Request for Advice – Newcastle Grammar School – Park Campus – Newcastle LGA

I refer to your request for advice on the Major Projects Portal, dated 19 November 2021 in which the Planning and Assessment Division (P&A) of the Department of Planning, Industry and Environment (the Department) invited Biodiversity and Conservation Division (BCD) to provide advice in relation to the Newcastle Grammar School – Park Campus Environmental Impact Statement (EIS) (SSD-13895306).

Newcastle Grammar School – Park Campus

Figure 1 – Subject Site Plan and evacuation routes

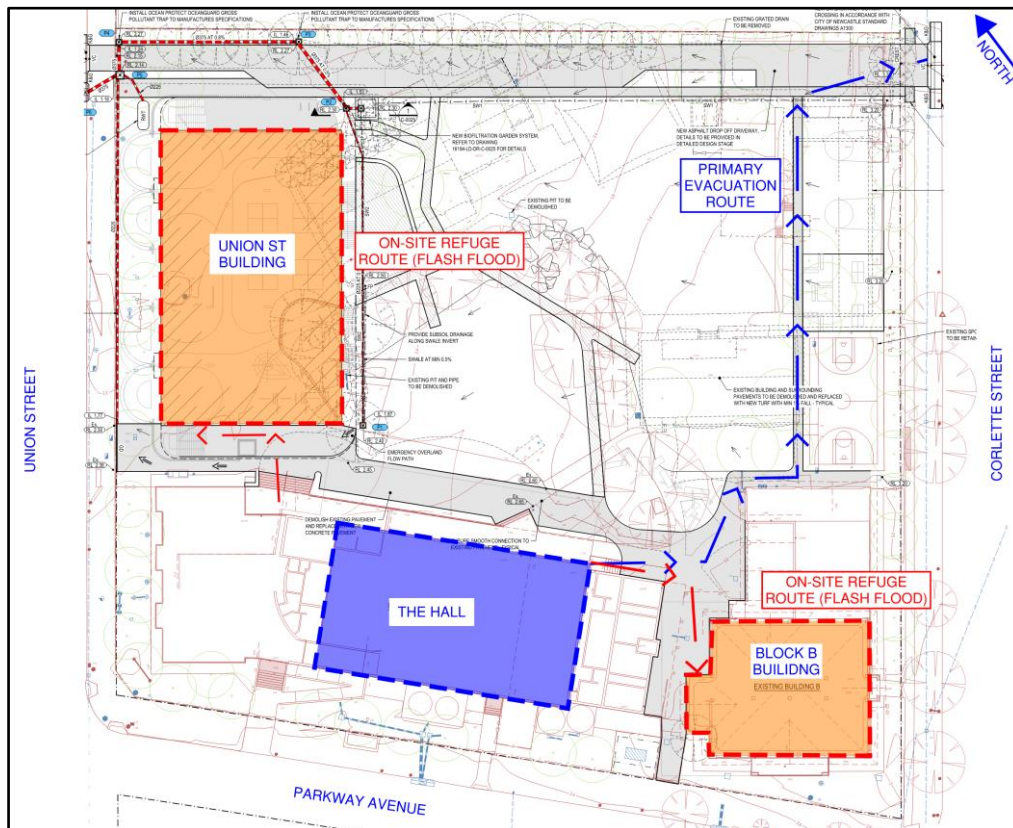
The evacuation route proposed in the FERP will be cut off early. The FERP incorrectly states that the evacuation route is upwards and away from rising floodwaters. The Tooke Street evacuation route is cut off at a local depression at the Bruce Street intersection, approximately 150m from the site by backwater flooding from runoff from the Strzlecki ridge and Nesca Park area. Given the very fast rate of runoff off the Strzlecki ridge, the school cannot rely on the evacuation route being trafficable, even if they confirmed it was flood free at the start of the evacuation. BCD considers that the evacuation plan must provide a gradually rising evacuation route that can be negotiated without the need to cross floodwaters that increase in depth.

The FERP relies on an elevated walkway for the evacuation route to the on-site refuge. However, no information is provided on the required height of the walkway or requirements for the walkway to be able to withstand PMF flood forces. BCD recommends that:

- the walkway is to have a minimum elevation of 3.2m (AHD) so that it provides rising access to the flood refuge.
- the walkway is to have a minimum width of 1.5m for the walkway, to allow two evacuees to walk side by side.
- All classrooms are to be connected to the raised walkway by pathways with a minimum elevation of 3.2m (AHD).

- The proposed raised walkway:
 - has a minimum elevation of 3.2m AHD
 - has minimum width of 1.5m
 - is connected to all classrooms by pathways with a minimum elevation of 3.2m AHD

- is certified by a structural engineer to withstand the hydraulic forces of the PMF conditions.

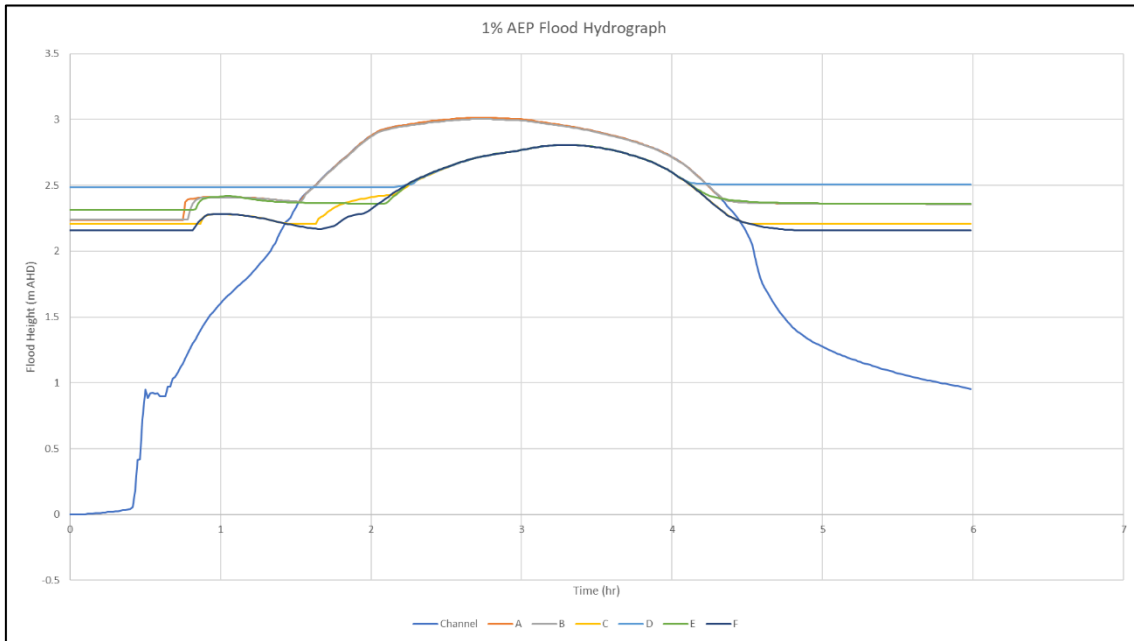
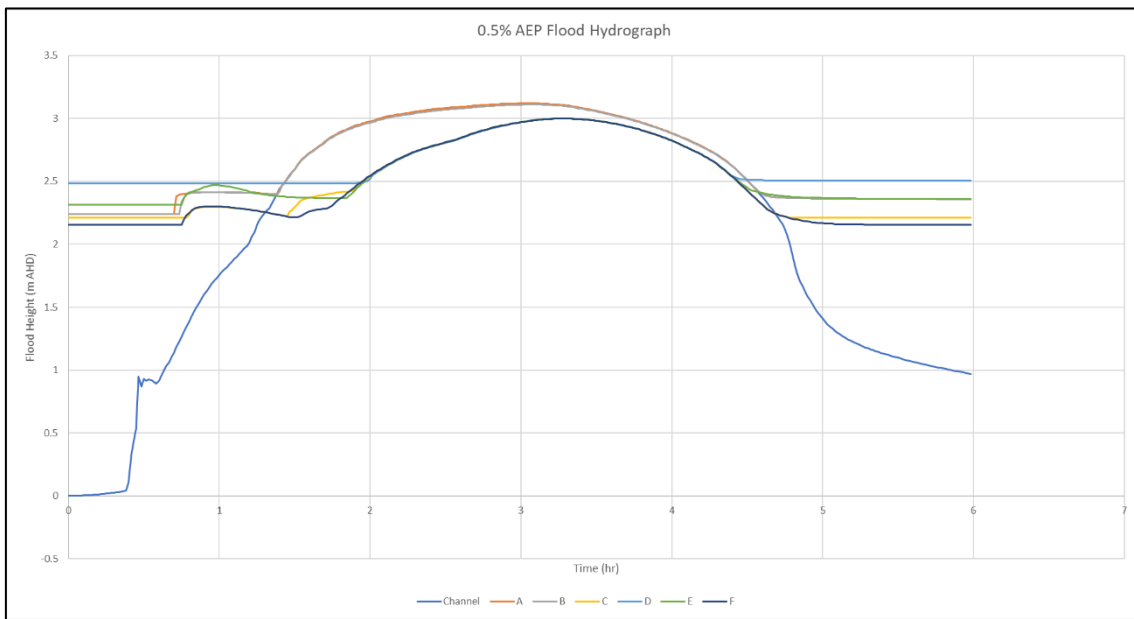
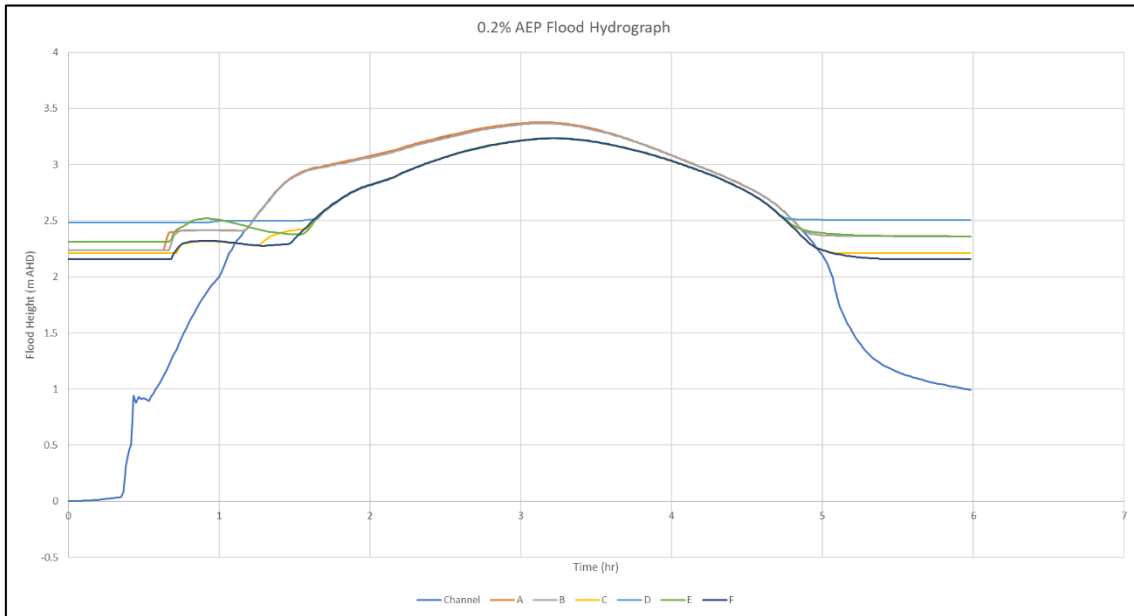
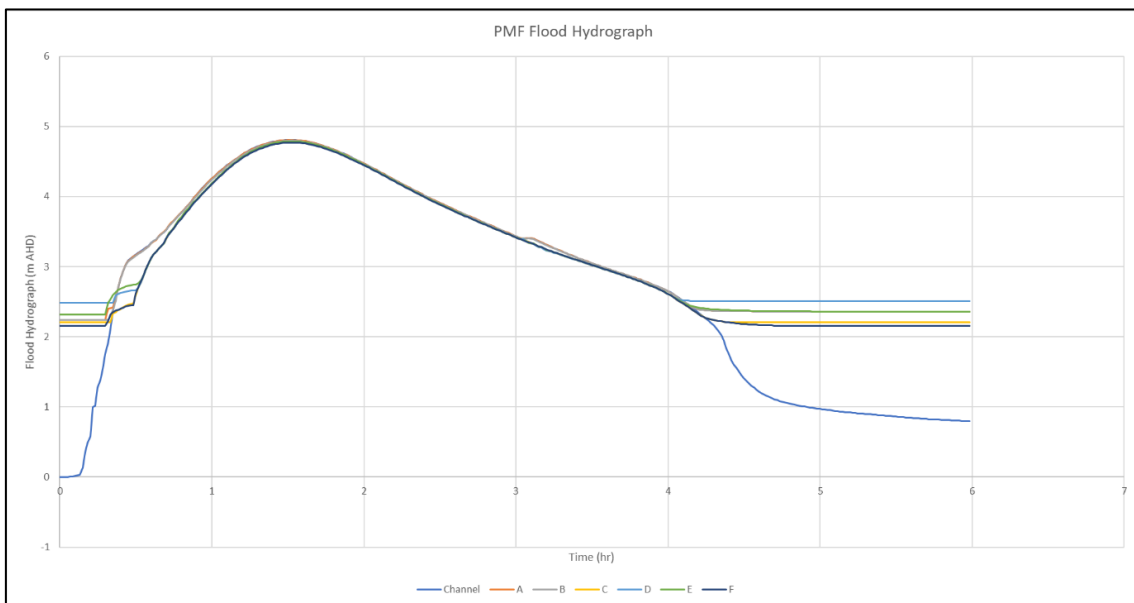
The Flood Impact Assessment prepared by Torrent Consulting does not provide adequate information to determine the time available to evacuate (or seek onsite refuge). Pre-incident planning needs to include a realistic assessment of the time required to evacuate. This requires hydrographs for the 1%, 0.5%, 0.2% and the PMF events to determine:

- available warning time
- time available to evacuate after evacuation triggers are reached
- length of time Cottage Creek stays at its peak
- duration of isolation for people sheltering in place.

BCD recommends that the proponent provides hydrographs for the 1%, 0.5%, 0.2% and the PMF events.
